While the Woodland Trust has not registered to become an interested party on the proposed scheme, we do hope you are able to take the following comments into consideration.

DRAWING TITLE
Figure 5.1(c) Fixed South Facing Central Inverter Illustrative Development Layout

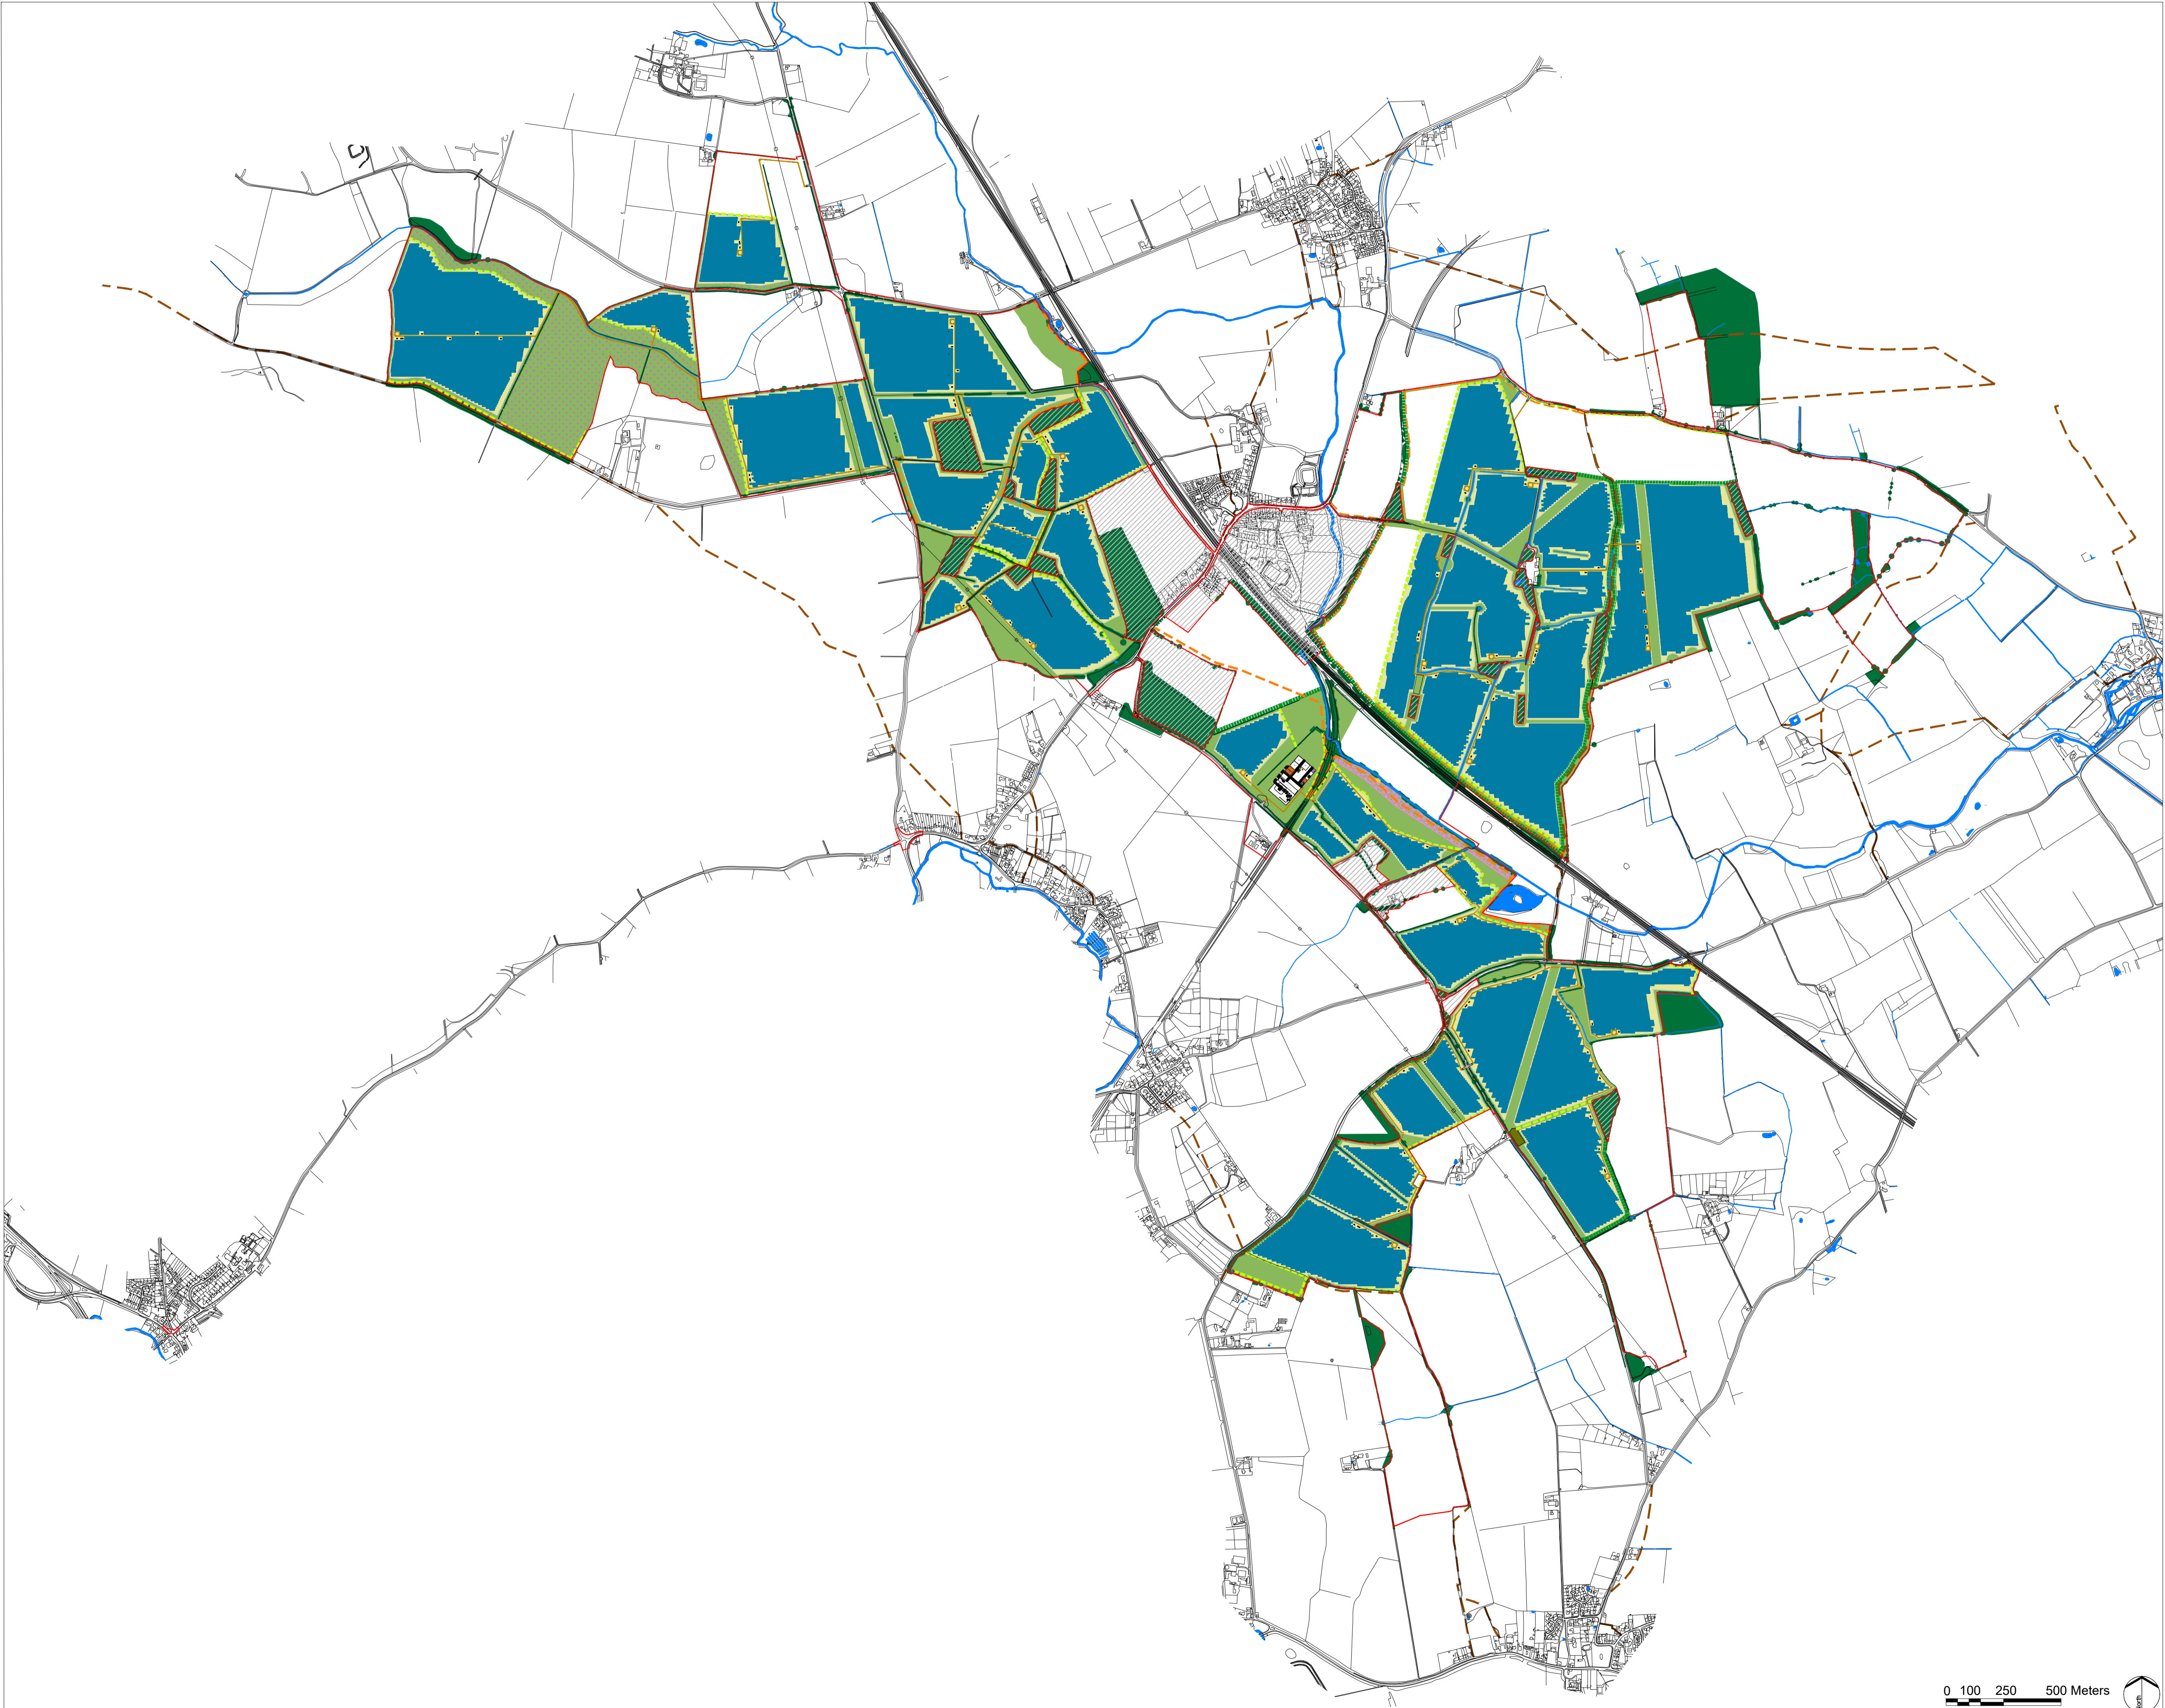
There are three veteran oak trees across the proposed site which may be subject to root encroachment and impact unless suitable mitigation is provided. Please see the trees in question below, and our suggestions for their protection:

The veteran buffer zones of P-T010 and M-T061 will be partially located within the proposed solar farm area; it is therefore imperative that these buffer zones remain free of development to ensure the long-term vitality of the veteran specimens.

P-T031 will be subject to potential root encroachment from the siting of the internal access track. The applicants should look to re-locate the access track entirely from the veteran buffer zone or confirm that any works proposed will be undertaken to no-dig specifications as outlined in the BS:5837:2012.
